**Our ref:** Q080666  
**Your ref:** 19/01740/HYBRID and 19/01746/OUT  
**Email:** emma.lancaster@quod.com  
**Date:** 3 January 2020

## Catalyst Bicester – Amendments and Additional Information

Following on from our recent meetings and correspondence, I write to confirm amendments to planning applications 19/01740/HYBRID and 19/01746/OUT.

Drawing No. **18022 - TP - 101** | Rev.

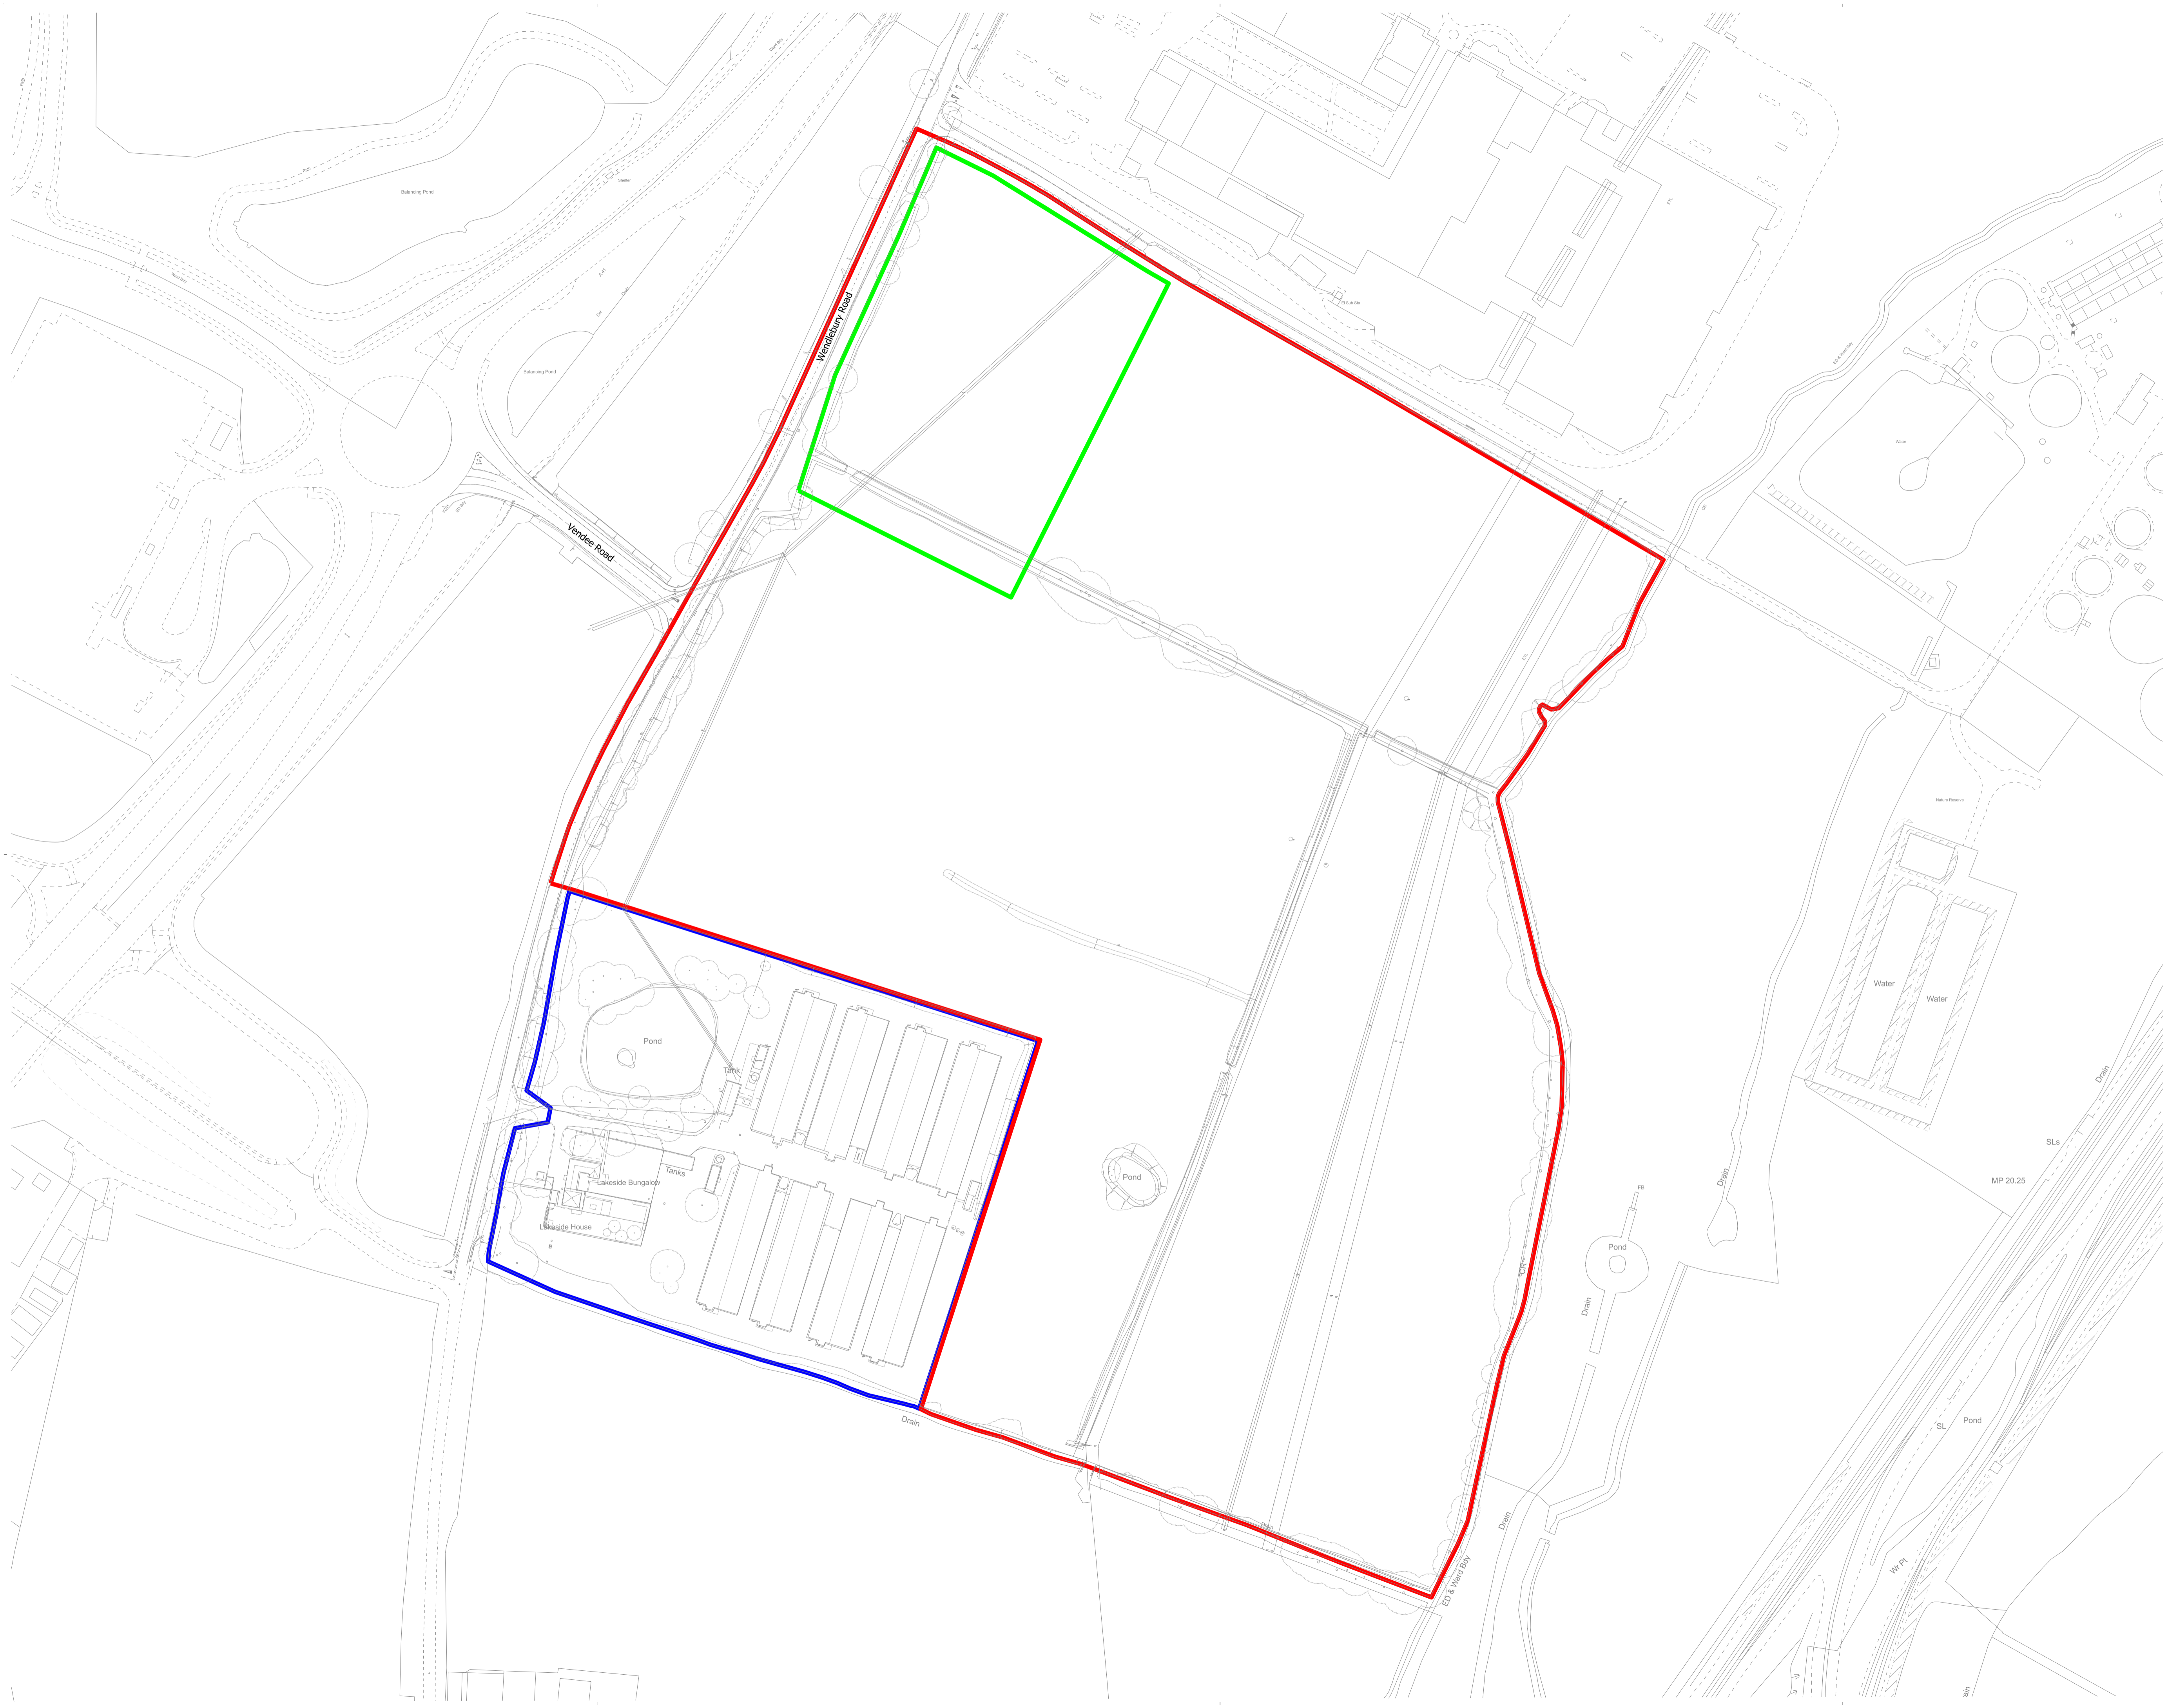
- The application boundaries have been amended: the area of overlap between the full and outline components of the submission has been removed – please refer to drawing no. 18022-TP-101 Rev B.
- The area covered by the outline planning application is therefore reduced.
- The Parameter Plans have been updated to reflect these amendments to the outline application.
- There is no change to the detailed component of the hybrid submission.
- Scenario 1 (B1 development across the whole of the site), as presented and tested in all the technical documents and Environmental Impact Assessment (EIA), is no longer possible and is **deleted** from the application.

Drawing No.	Rev.
18022 - TP - 111

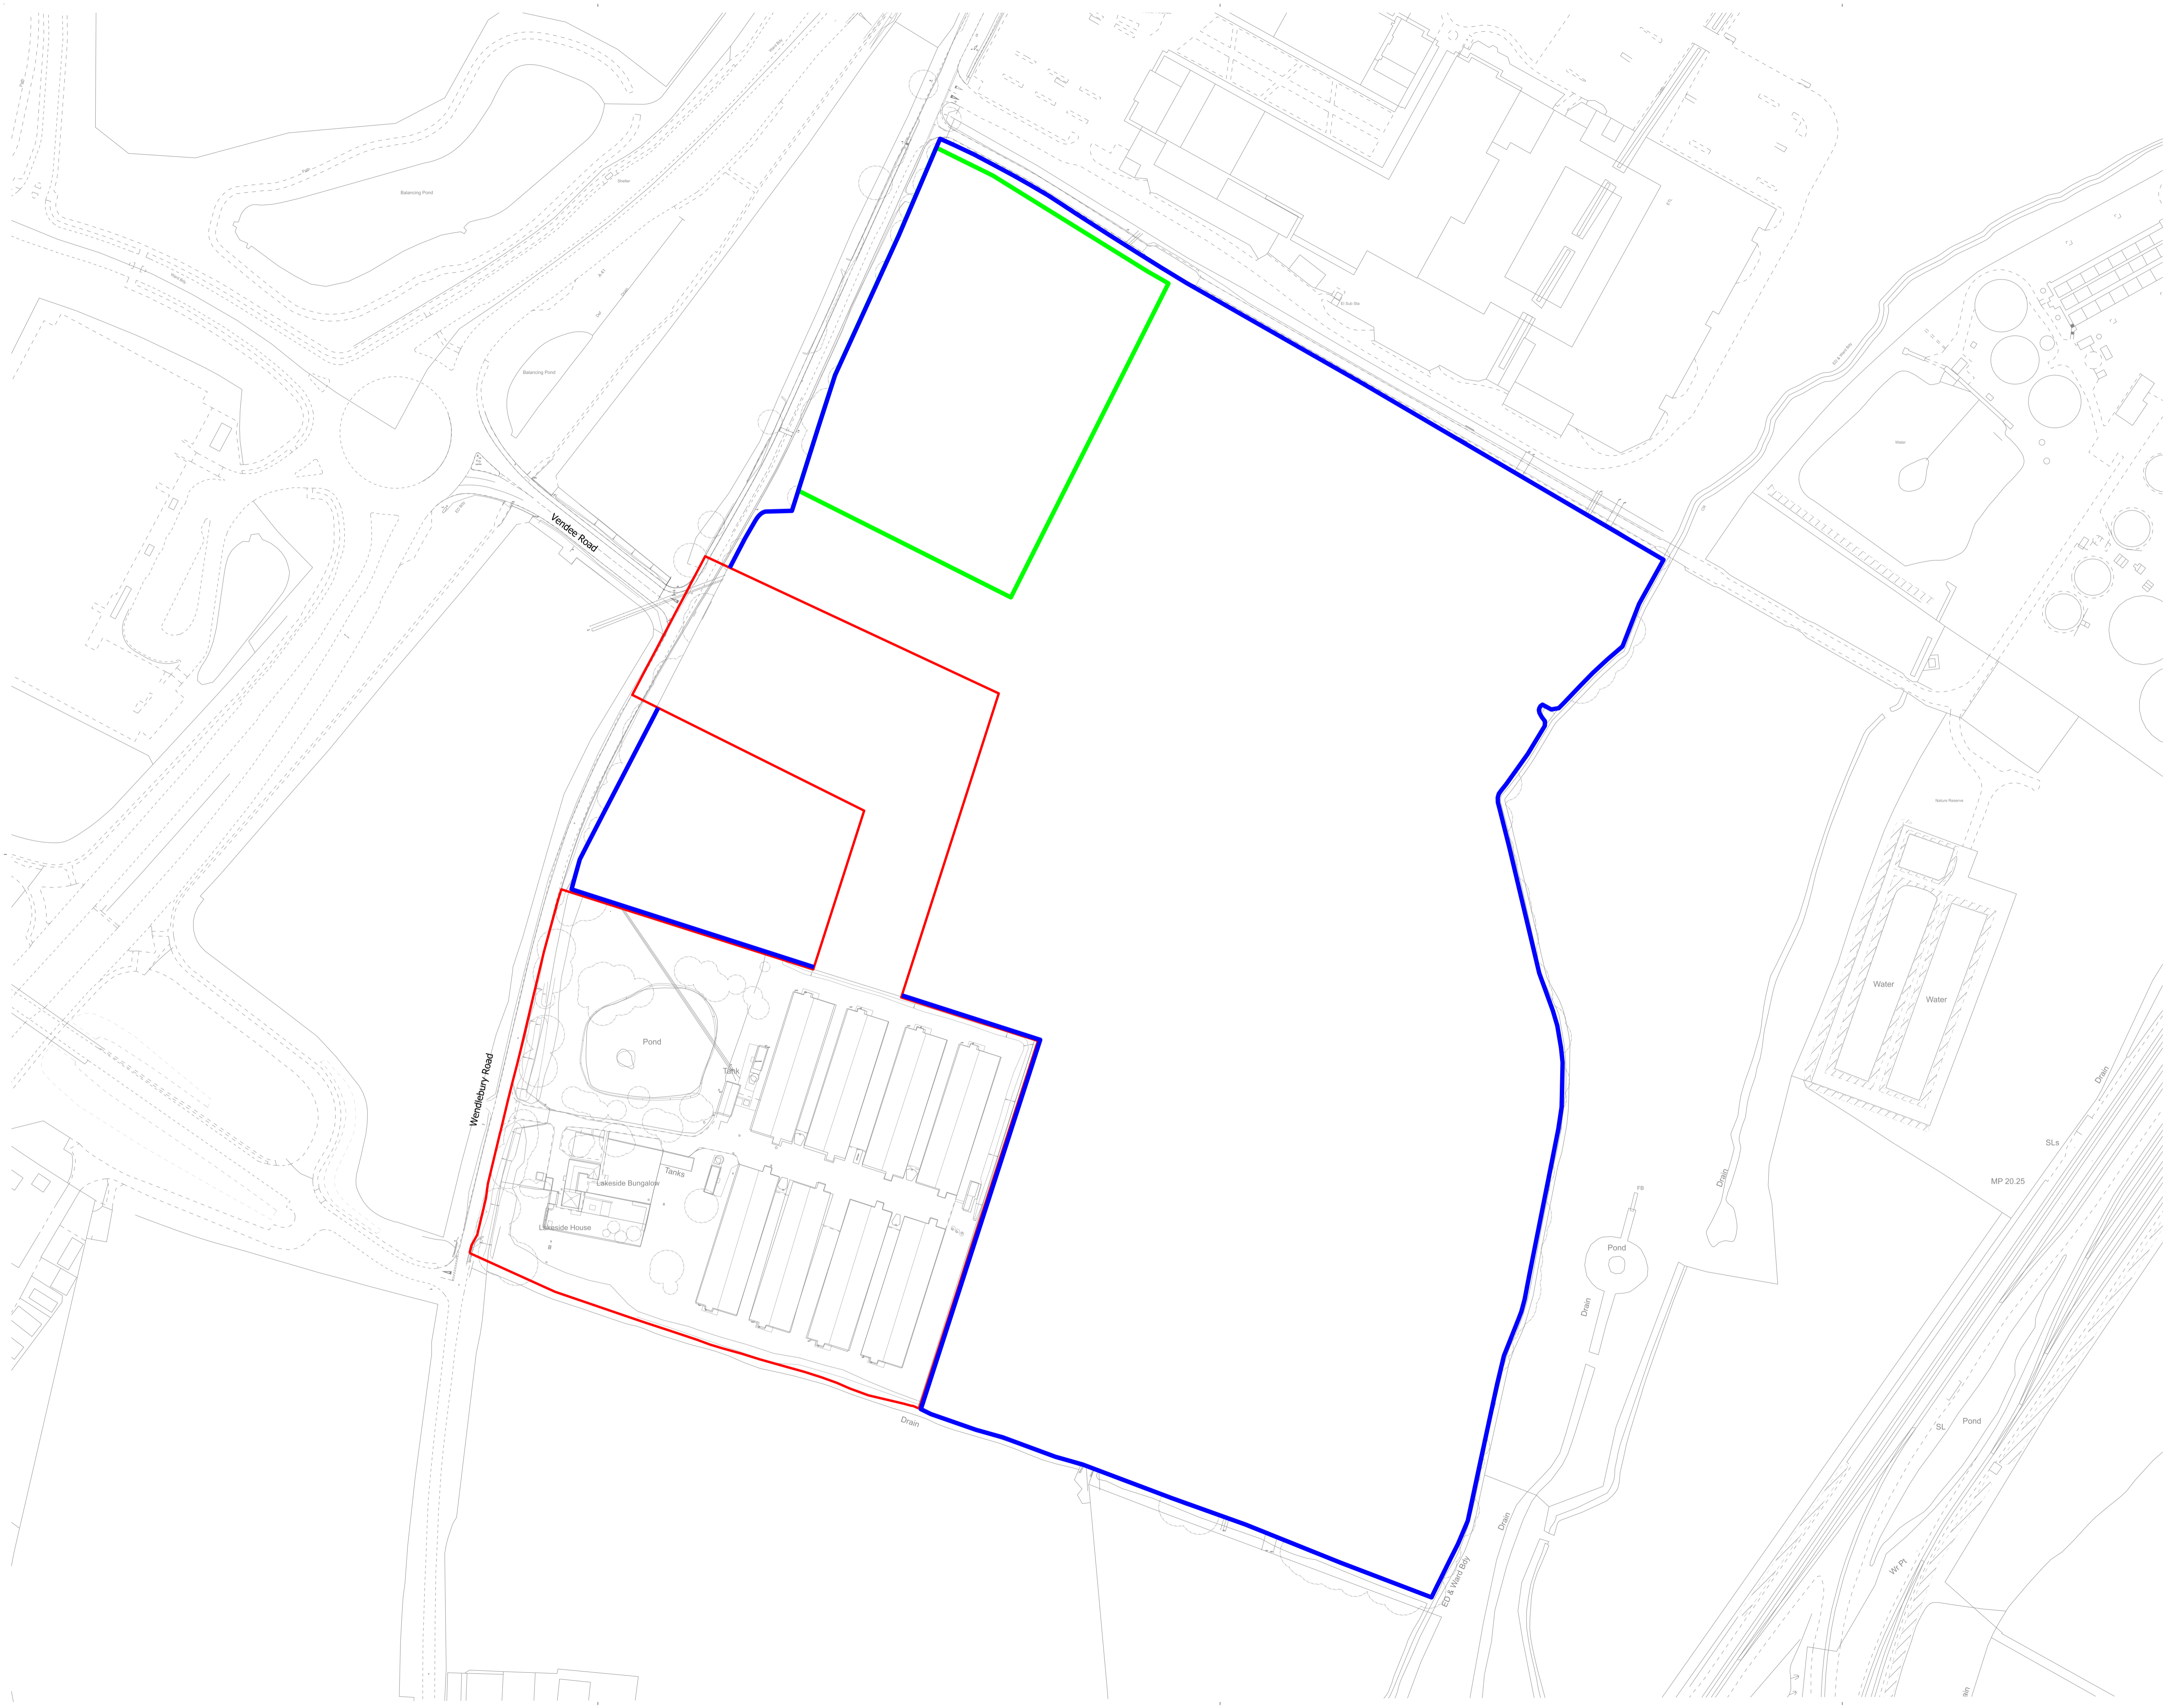
- The application boundary has been amended: the site includes all land required for highway works (including the proposed Wendlebury Road/Vendee Drive roundabout) which is not highway land – please refer to drawing no. 18022-TP-111 Rev B.
- The Parameter Plans have been updated to reflect this amendment.
- Because of the amendments to the hybrid application, Scenario 3 (B1 development across the whole of the hybrid application site and this application site), as presented and tested in all the technical documents and EIA, is no longer possible and is **deleted** from the application.
